Recommendation Report for Planning Permission for Works or Extension to a Dwelling

REF NO: **AW/236/13/**

LOCATION: 37 Lincoln Avenue
 Bognor Regis

PROPOSAL: Replacement single storey rear extension. Resubmission of AW/156/13. This application also lies within the parish of Pagham

CLIENT	PROJECT
W D PRIDDY	37 LINCOLN AVENUE ROSE GREEN ADC/3/13

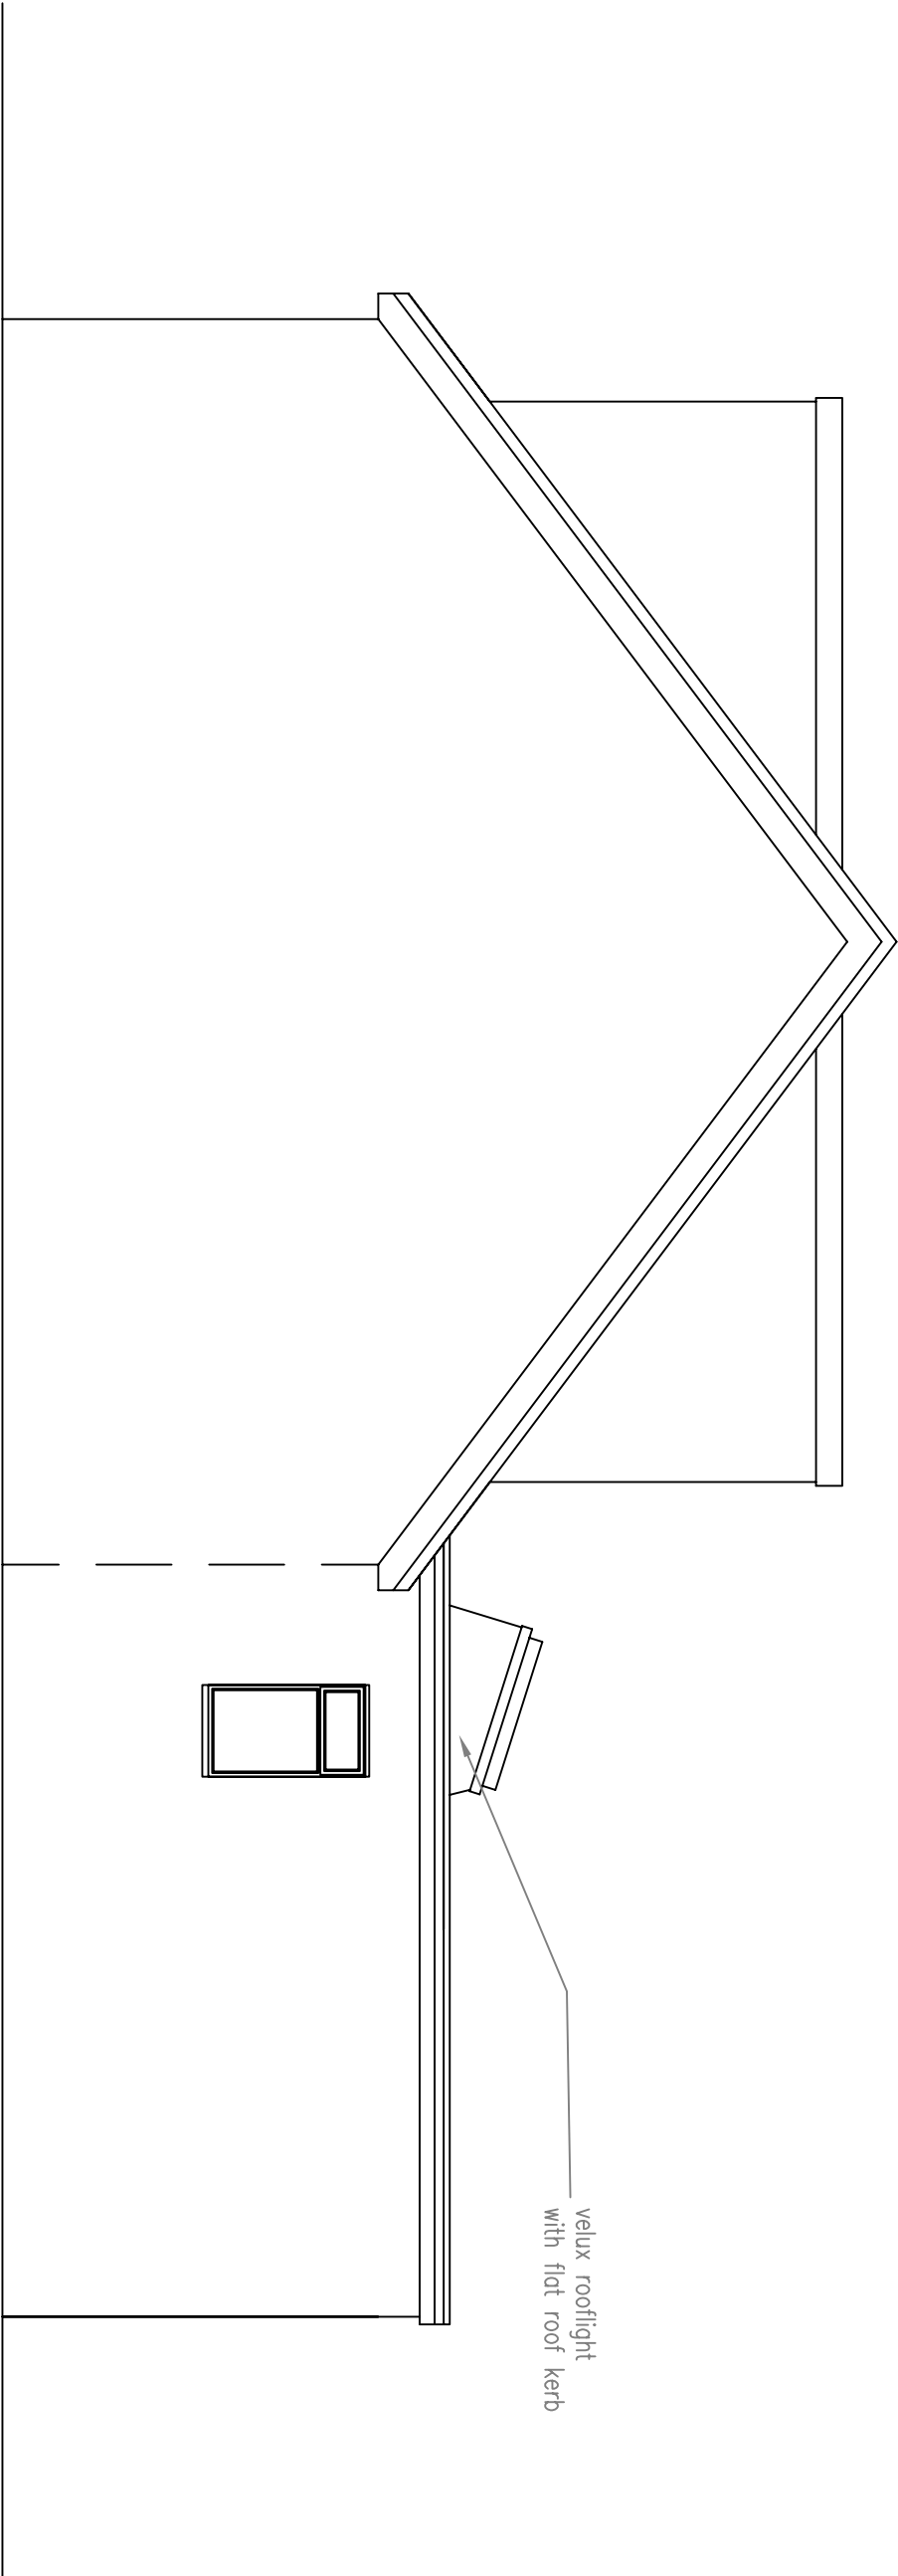
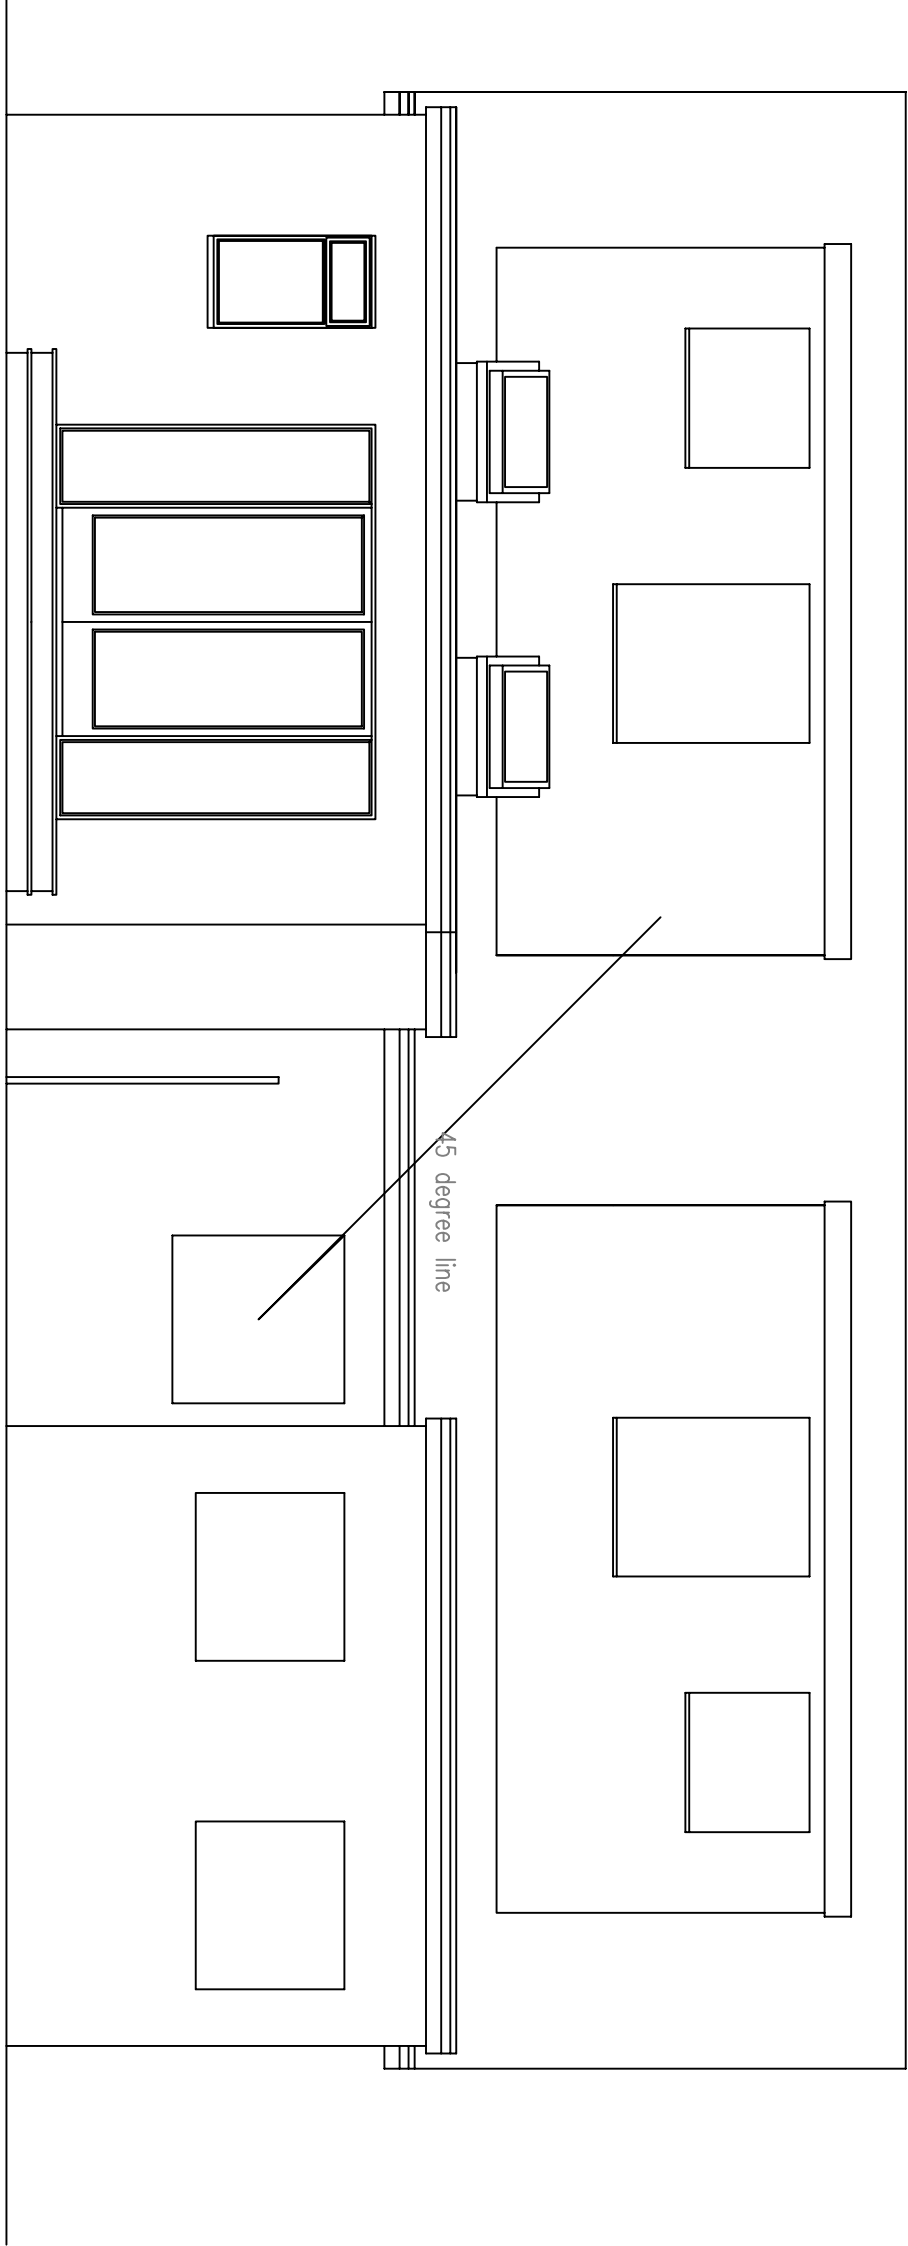
Notwithstanding the regulatory justification submitted by the applicants agent, concern was expressed at the partial cloaking of the fenestration of the adjacent property by the bulk and length of the proposed extension. Whilst acknowledging the design dilemma of seeking to secure the desired improvement in accommodation within the constraint of a narrow plot, members resolved, on balance, to register objection on the basis of prejudice to the amenity and quiet enjoyment of the adjacent dwelling.

The application for a single storey rear extension is a re-submission of a previously refused rear extension AW/156/13. The previous application was refused on the basis that the rear extension by reason of its rear projection would be detrimental to the residential amenities of the occupiers of the neighbouring property No 35. By reason of its rear projection it was in conflict with the 45

degree rule when measured from the middle point of the bedroom window on the neighbouring property No 35.

The revised plans now show that the rear extension being of the same width and height will be set in slightly from the side boundary with No 35 by approximately 0.3m. The rear projection at this point adjacent to No 35 is 3.6m then extending to a depth of 4.9m. In view of this revision it now complies with the 45 degree line when measured from the mid point of the neighbouring bedroom window. The southern side boundary has fencing approximately 1.8m in height and it is noted that the neighbouring property No 35 has planted hedging behind this fencing which is slightly higher than the fencing. An extension not exceeding 3m in depth and 3m in height could be constructed in this location without the need for the submission of a formal planning application. The rear projection of the extension at this point with No 35 is 3.6m and whilst it is noted that the extension may be visible above the boundary fencing by approximately 1.1m it is not considered that this would create a loss of outlook or unacceptable overshadowing to recommend refusal.
